**Consultation Response from KC,
Highways Development Management**

2024/91814 land off, Soureby Cross Way, Birkenshaw, BD4 6PZ

Change of use of land from equestrian use to dog exercise area and associated works

Date Responded: 21/08/2024.

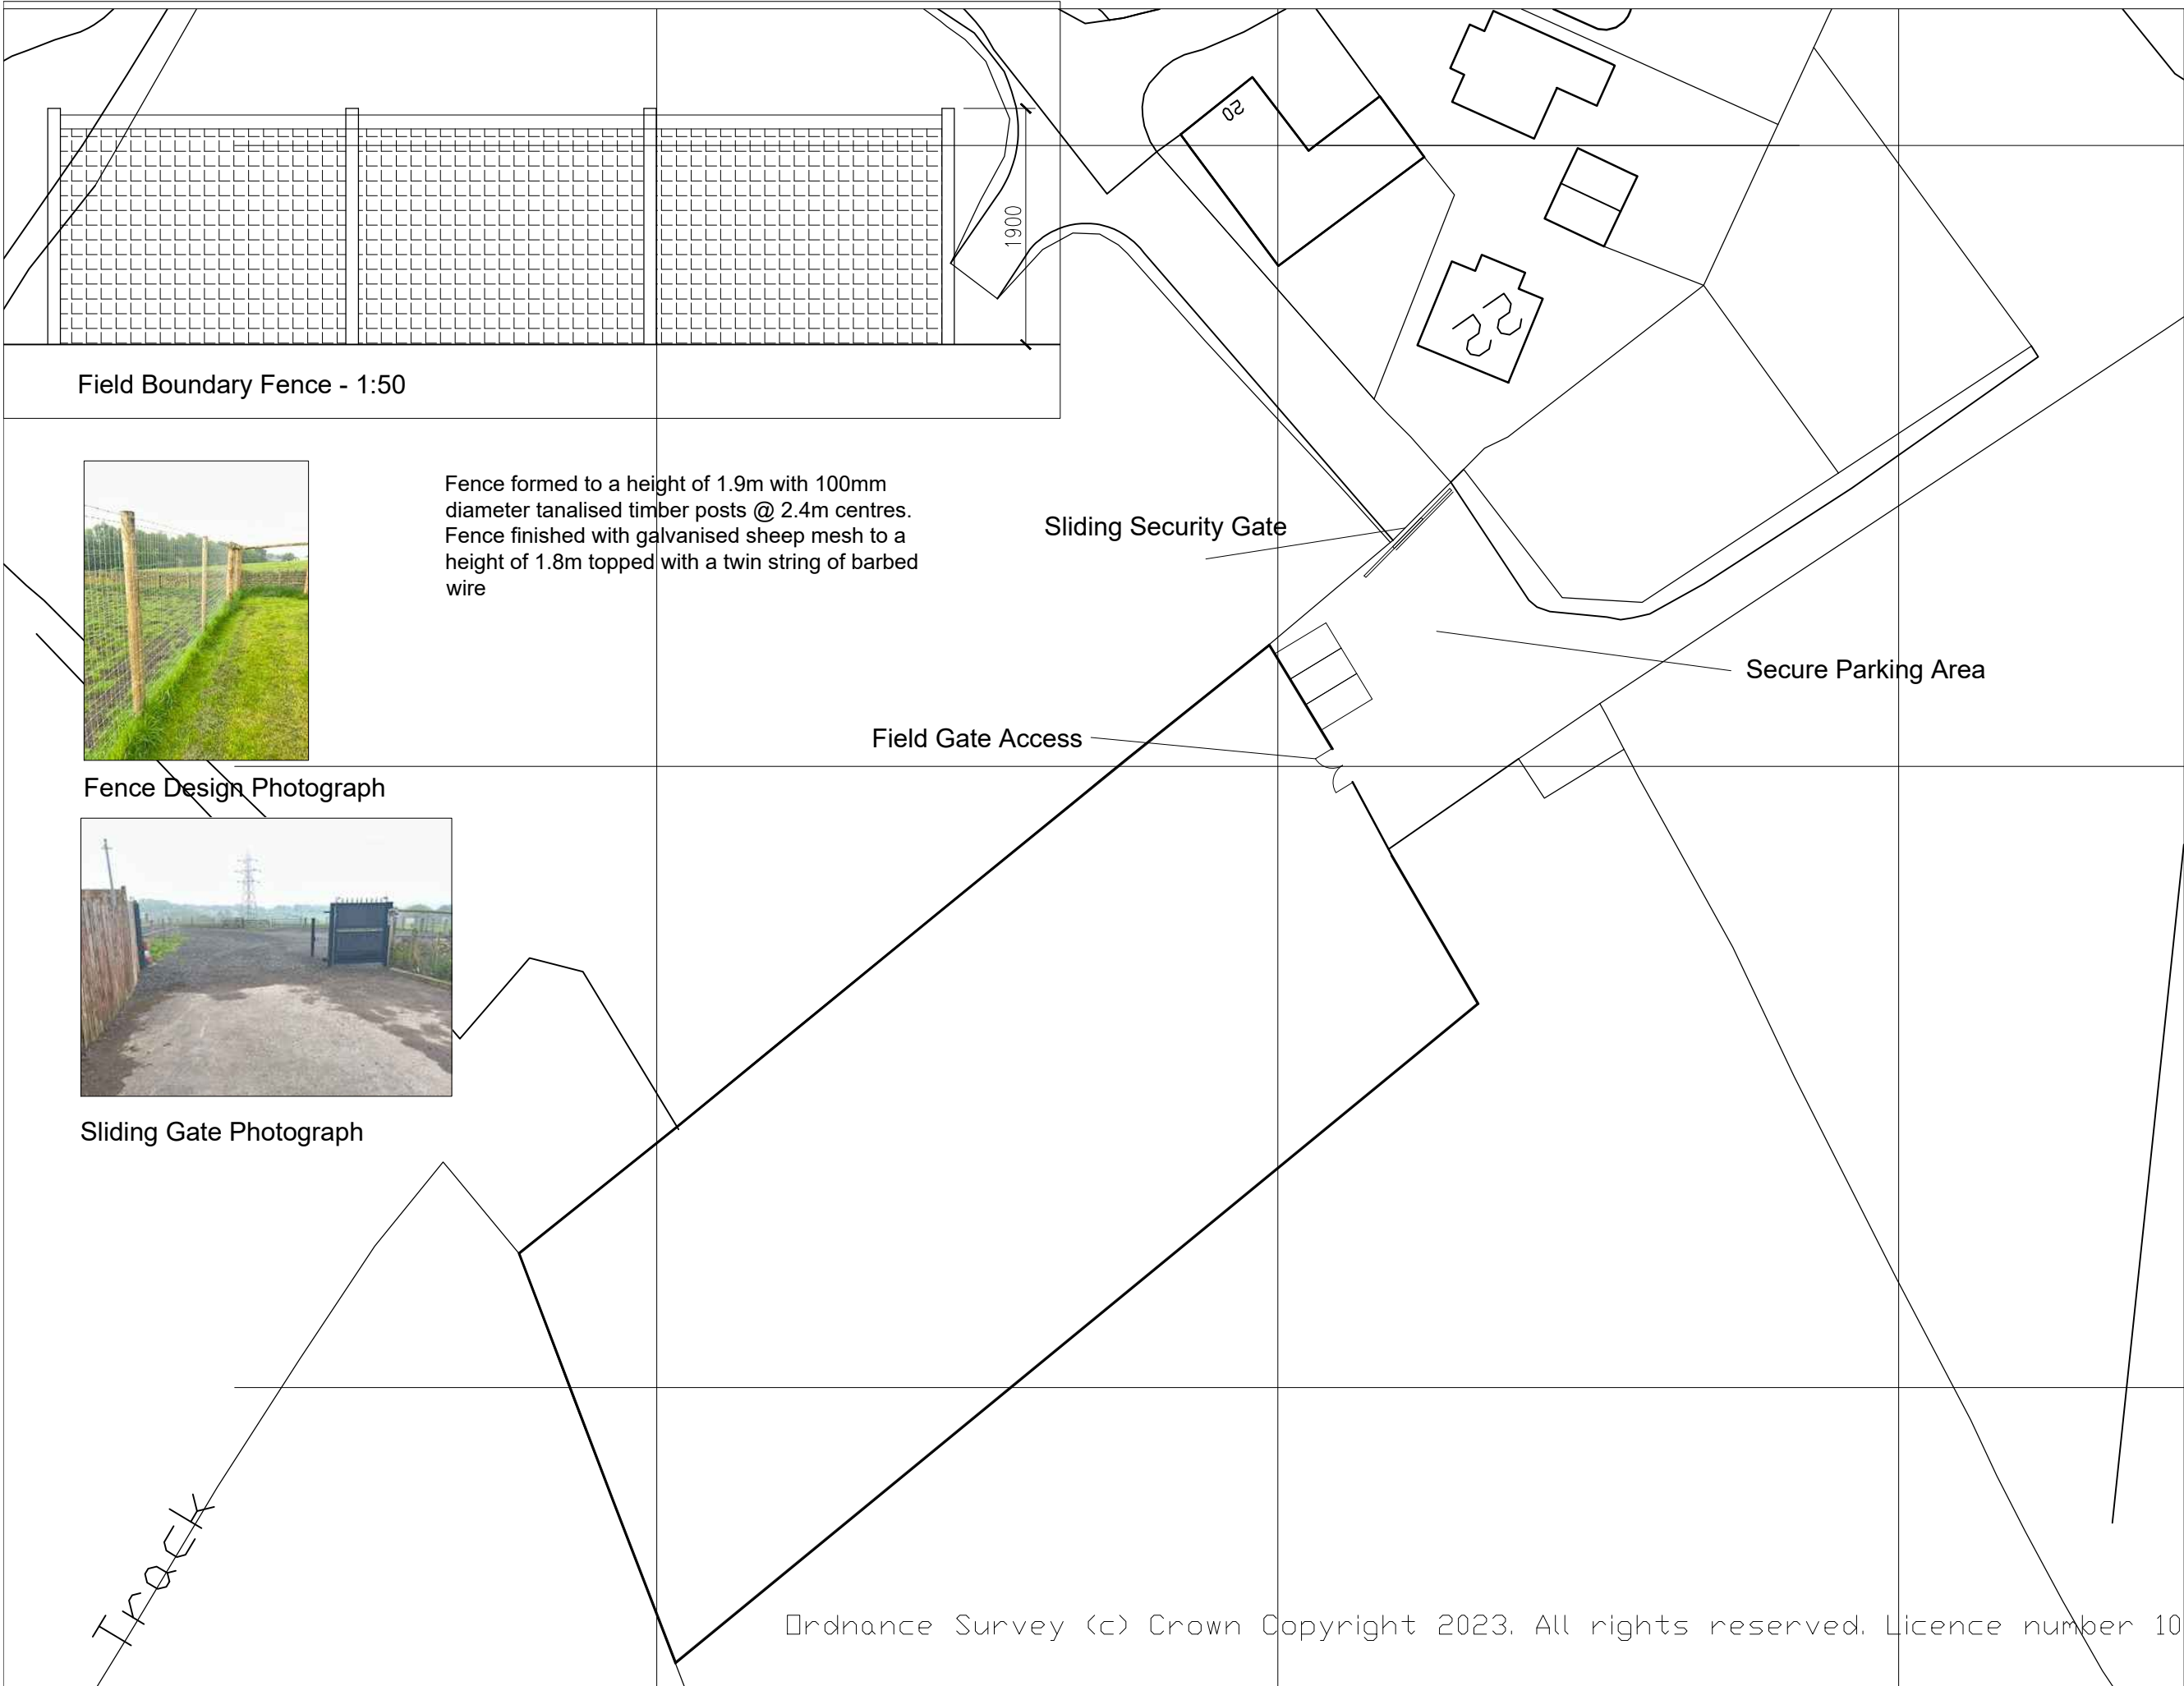
Three off-street car parking spaces are proposed and the car parking area is large enough to accommodate a vehicle turning area to enable vehicles to enter and leave the site in forward gear.

The approved vehicle parking areas will need to be surfaced and drained in accordance with the Communities and Local Government; and Environment Agencies 'Guidance on the permeable surfacing of front gardens (parking areas)' published 13th May 2009 (ISBN 9781409804864) as amended or superseded.
